CITY OF ALBUQUERQUE PLANNING DEPARTMENT May 8, 2013 DRB Comments

PROJECT # 1001928

APPLICATION # 13-70524

RE: Block 48, NM Town Co. Original Townsite

SKETCH PLAT OF
LOT 1-A, BLOCK 48
 NEW MEXICO TOWN COMPANY ORIGINAL TOWNSITE
 ALBUQUERQUE, BERNALILLO COUNTY, NEW MEXICO
 OCTOBER 2012

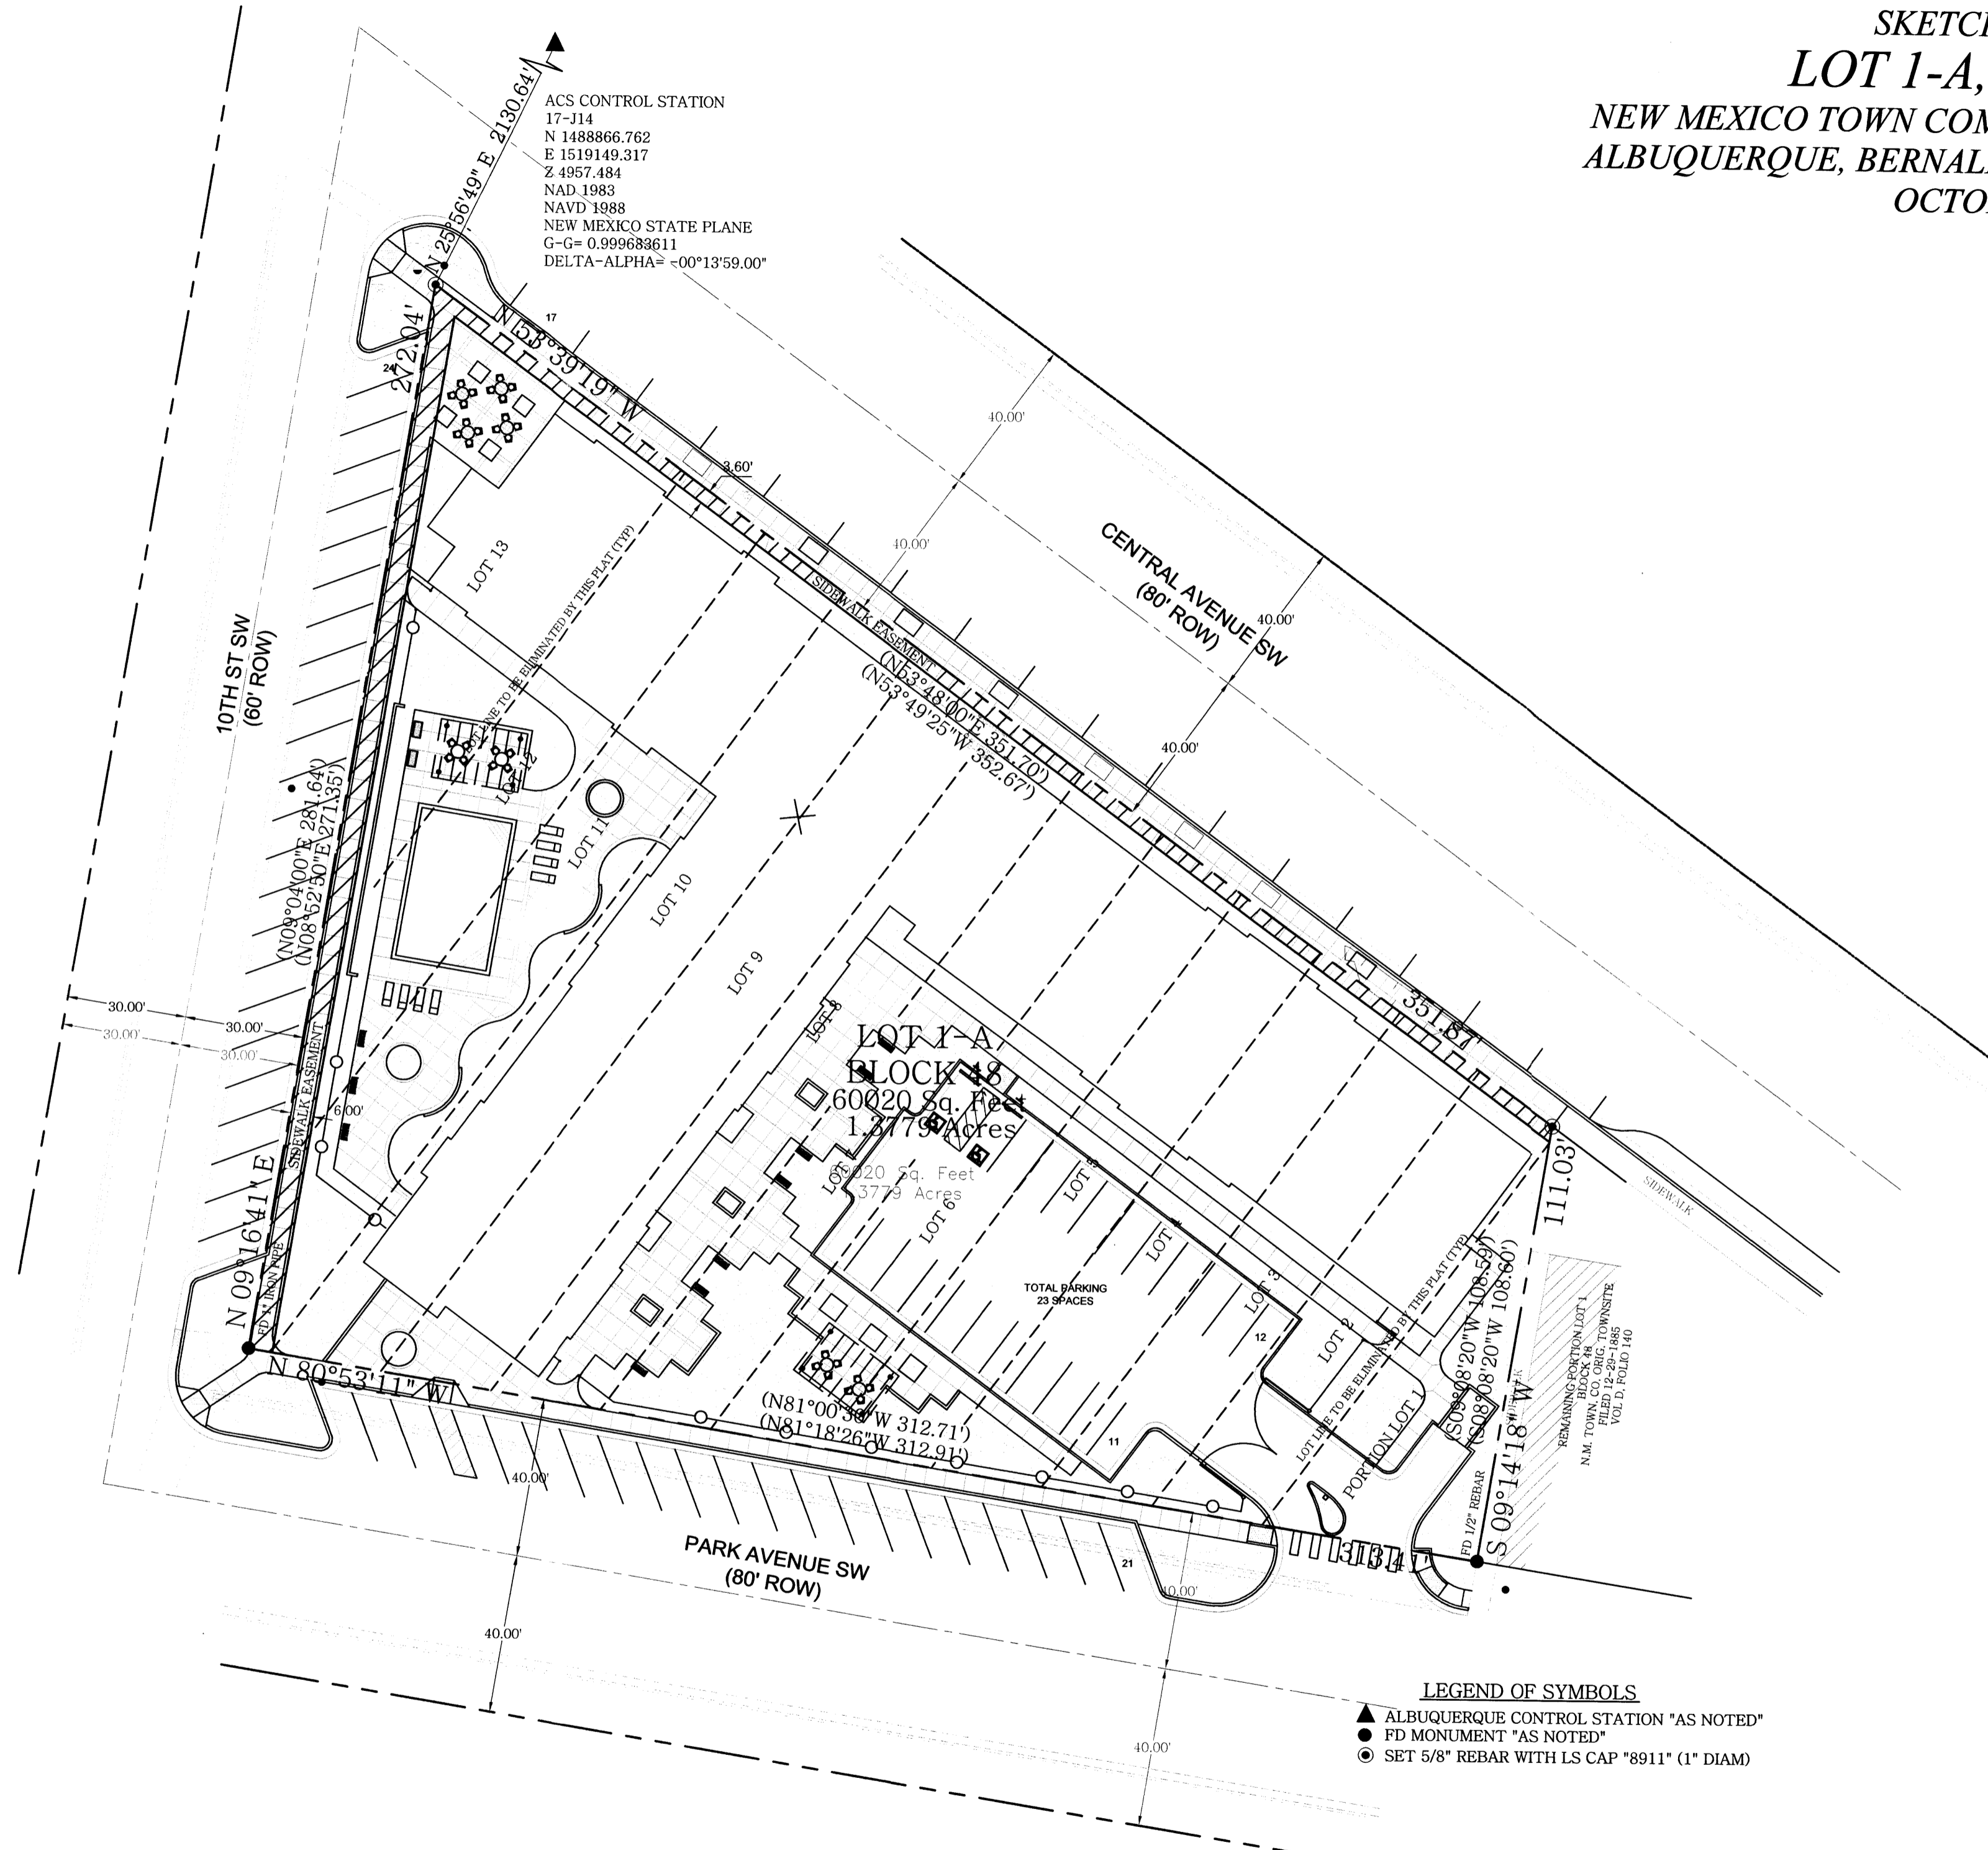
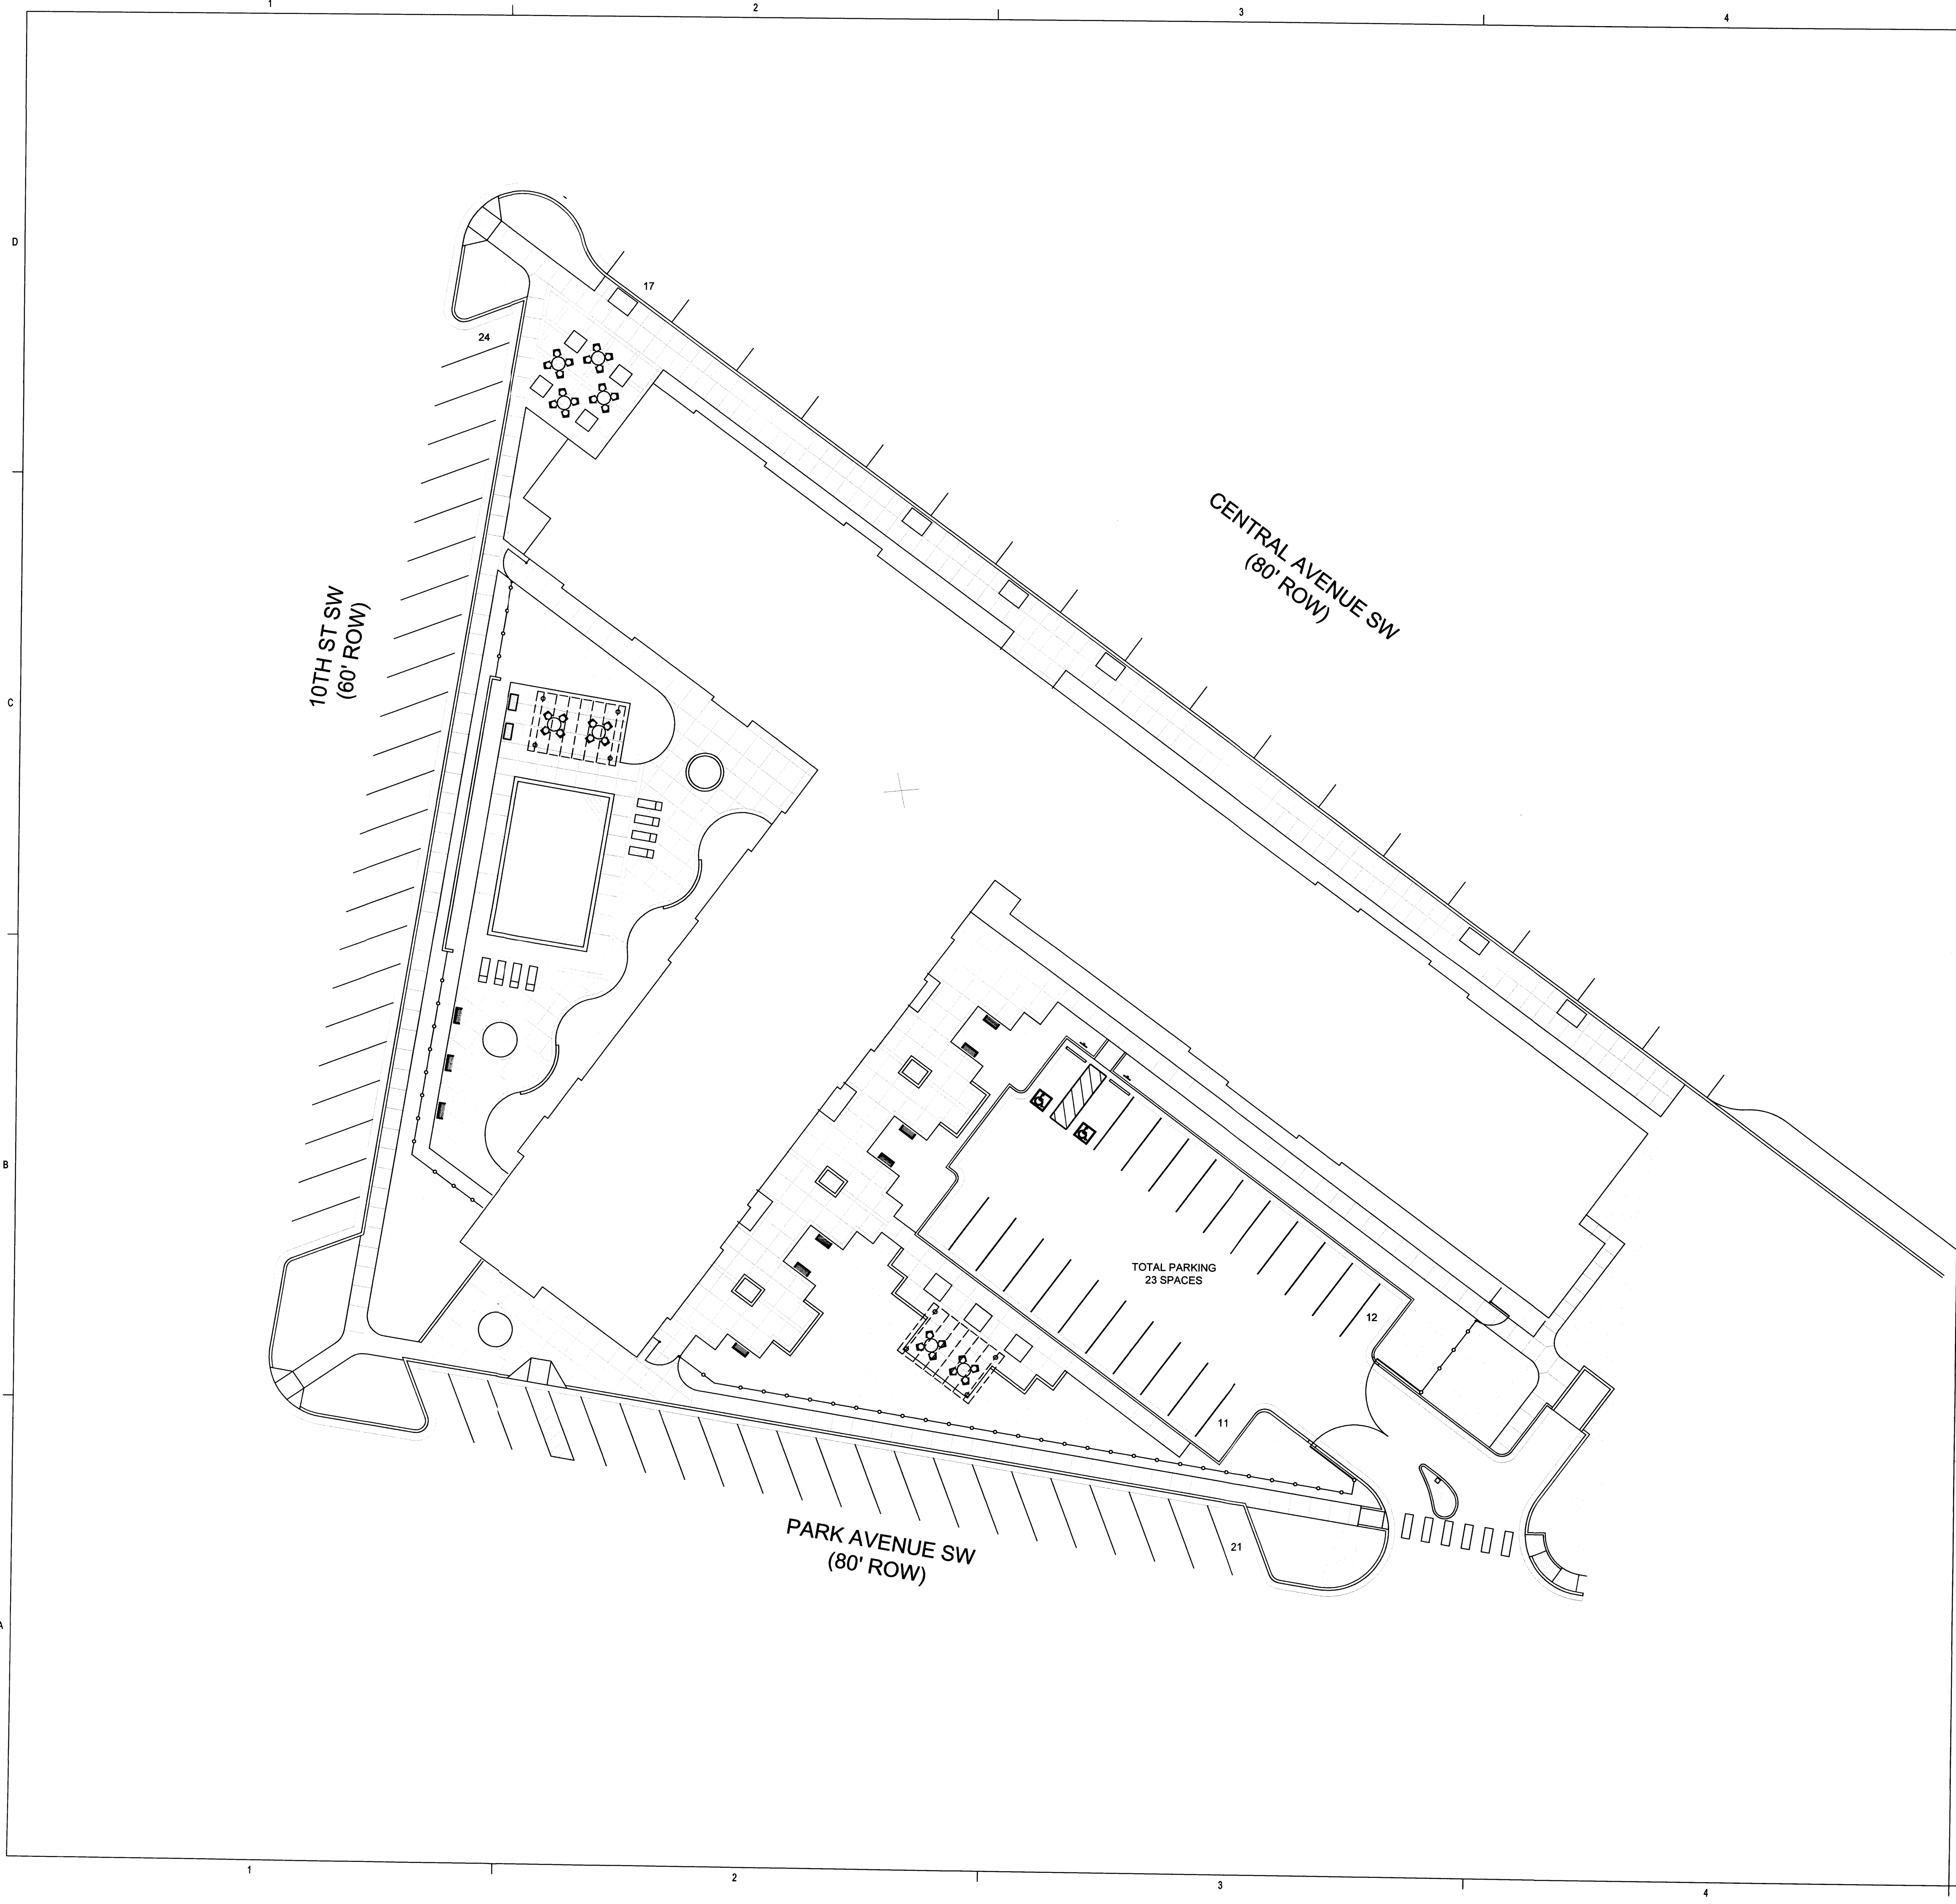
Sketch Plat legal description does not correspond to lot numbers on Albuquerque's Geographic Information System (AGIS). Also, for future reference: 1) please use the AGIS zone atlas page for city plats; 2) do not put zoning information on the final plat; and 3) Talos Log No.s are no longer issued or applicable.

Refer to comments from Transportation Development regarding proposed Sidewalk Easement.
